From: Laura Gibbons
Sent: 15 July 2019 11:39
To: Planning.Responses <Planning.Responses@arun.gov.uk>
Cc: Anita Gardner <Anita.Gardner@arun.gov.uk>
Subject: RE: Planning Consultation on: M/53/19/PL

Engineers Comments Regarding Surface Water Drainage

APPLICATION NO: M/53/19/PL

Description of Works: Demolition & erection of 1 No. dwelling.

Proposed soakaway
4.8m(L) x 3.6m(W) x 0.84m(D)

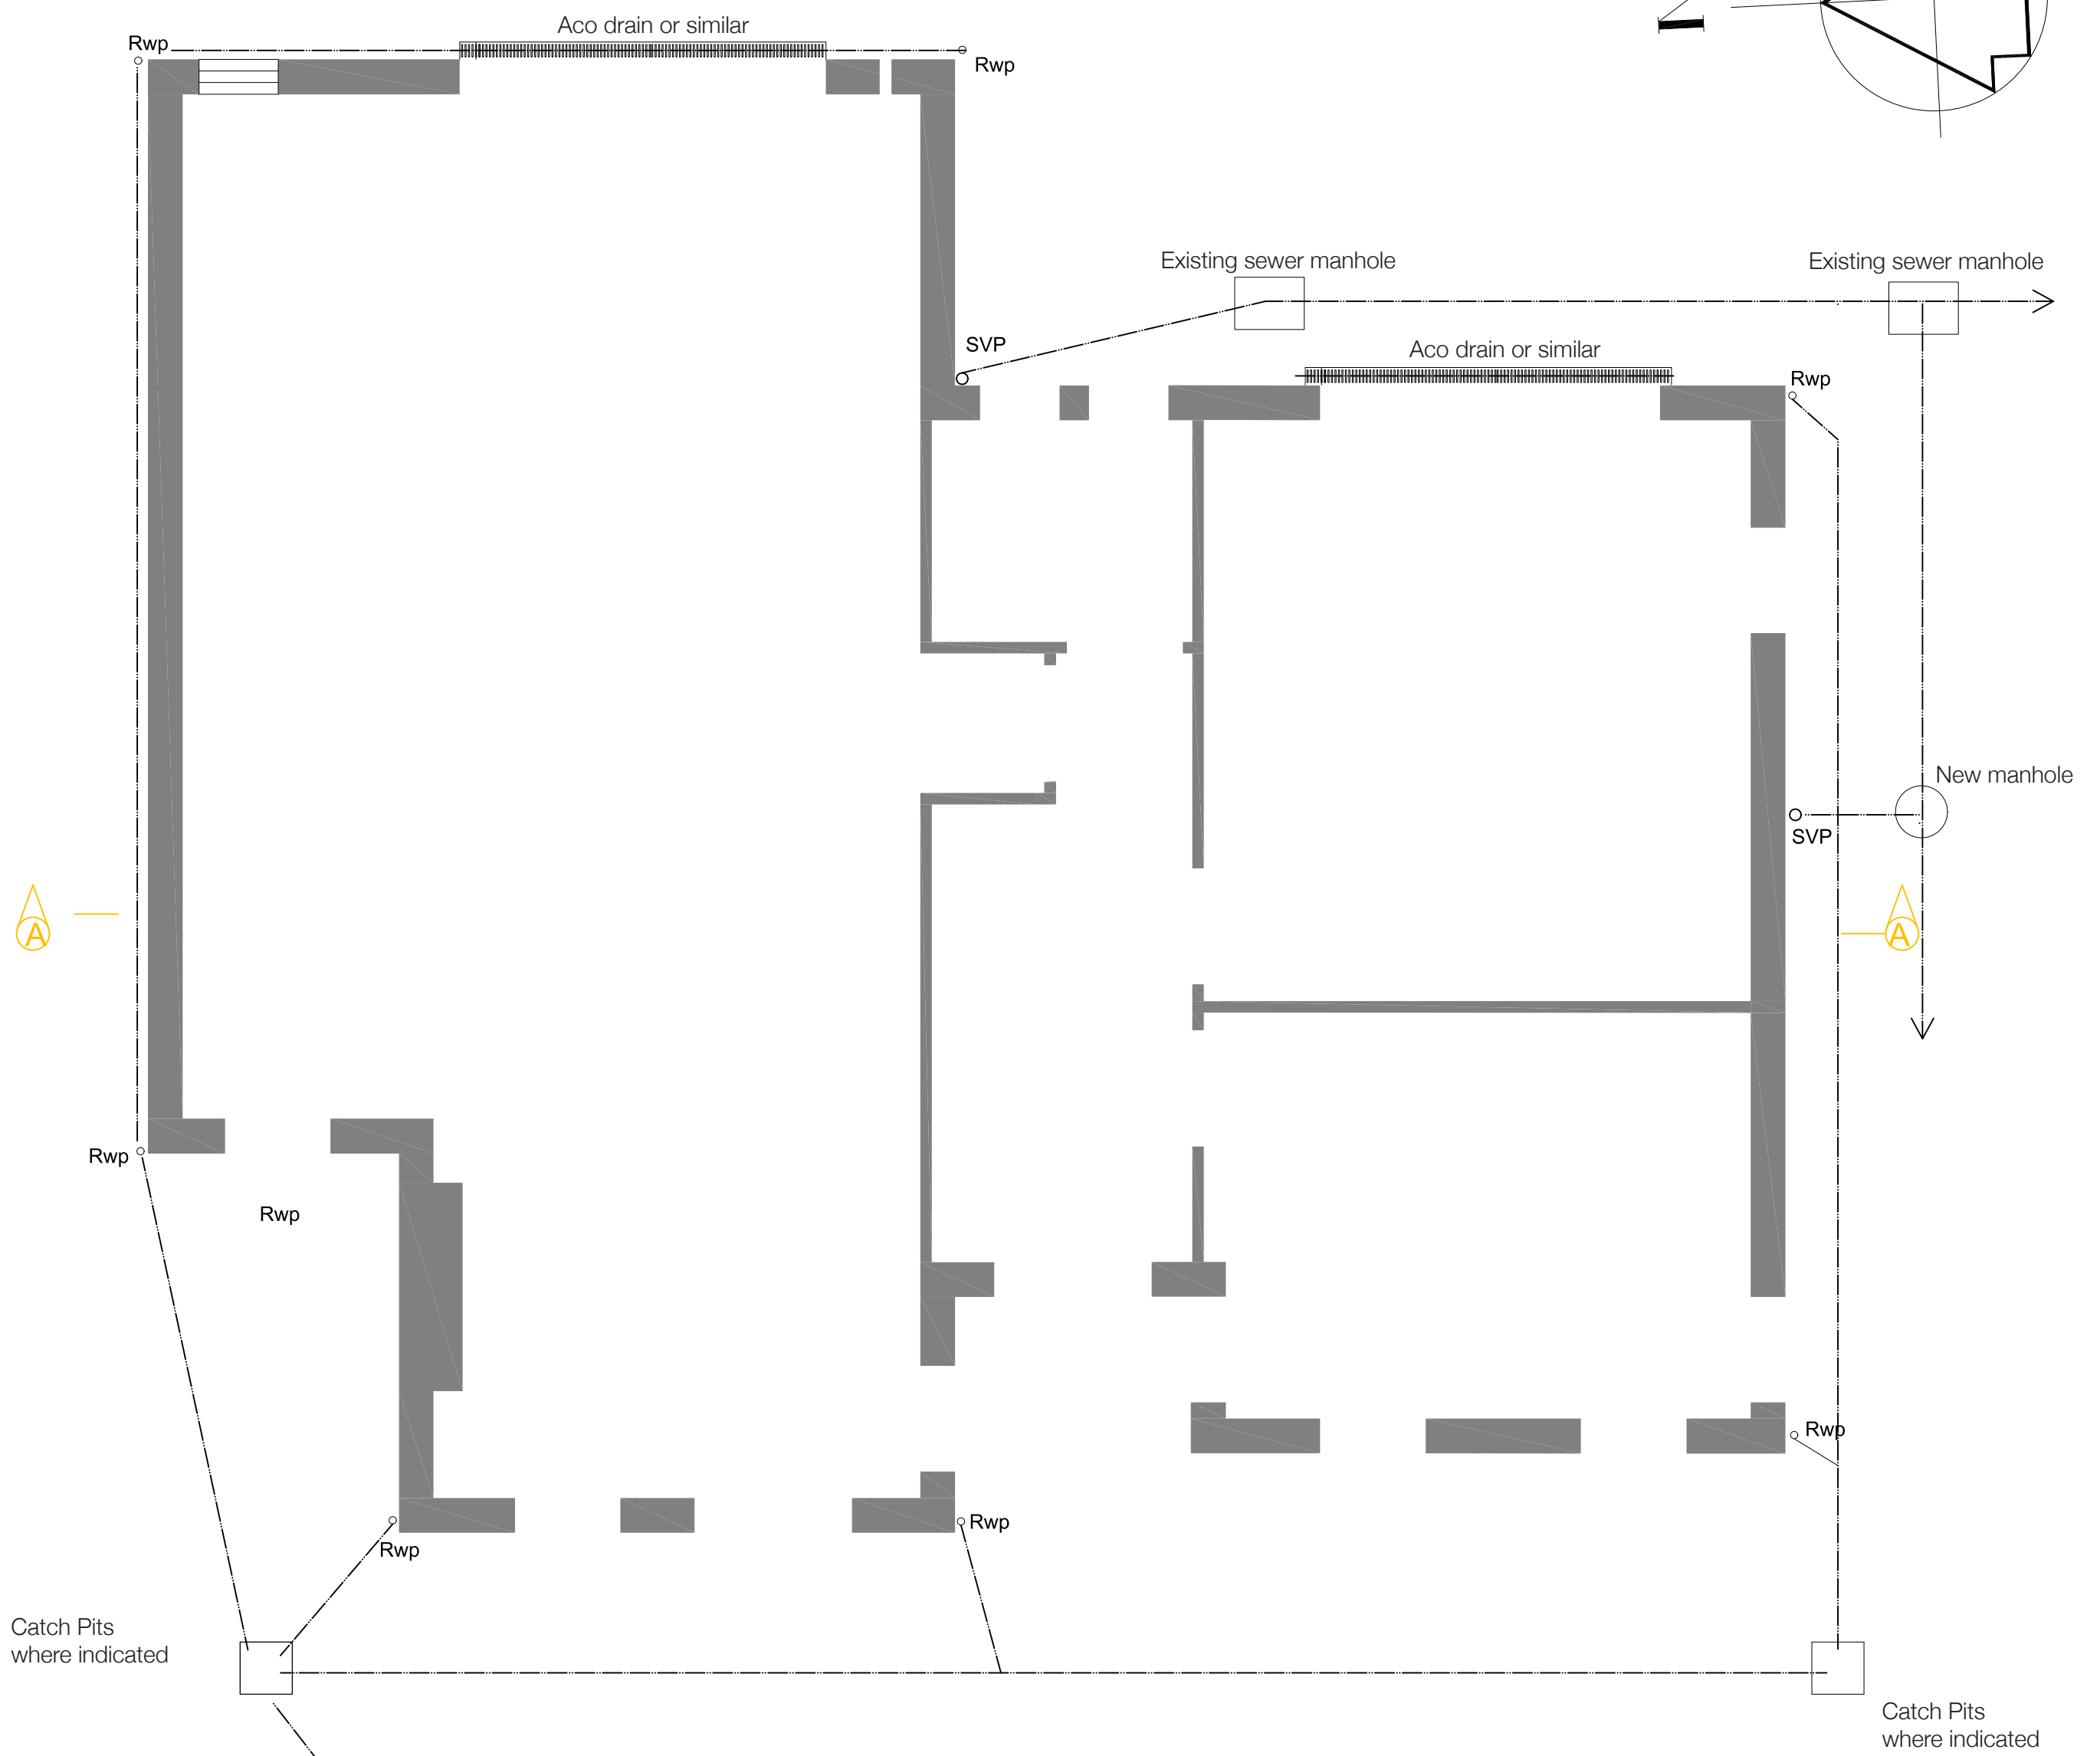
The applicant has submitted some details of the surface water drainage proposals. However, no winter groundwater monitoring results have been provided, the date of infiltration testing is unclear and no drawings have been submitted to demonstrate the proposals.

"Development shall not commence, other than works of site survey and investigation, until full details of the proposed surface water drainage scheme have been submitted to and approved in writing by the Local Planning Authority. The design should follow the hierarchy of preference for different types of surface water drainage disposal systems as set out in Approved Document H of the Building Regulations, and the recommendations of the SuDS Manual produced by CIRIA. Winter groundwater monitoring to establish highest annual ground water levels and winter Percolation testing to BRE 365, or similar approved, will be required to support the design of any infiltration drainage. No building / No part of the extended building shall be occupied until the complete surface water drainage system serving the property has been implemented in accordance with the agreed details and the details so agreed shall be maintained in good working order in perpetuity."
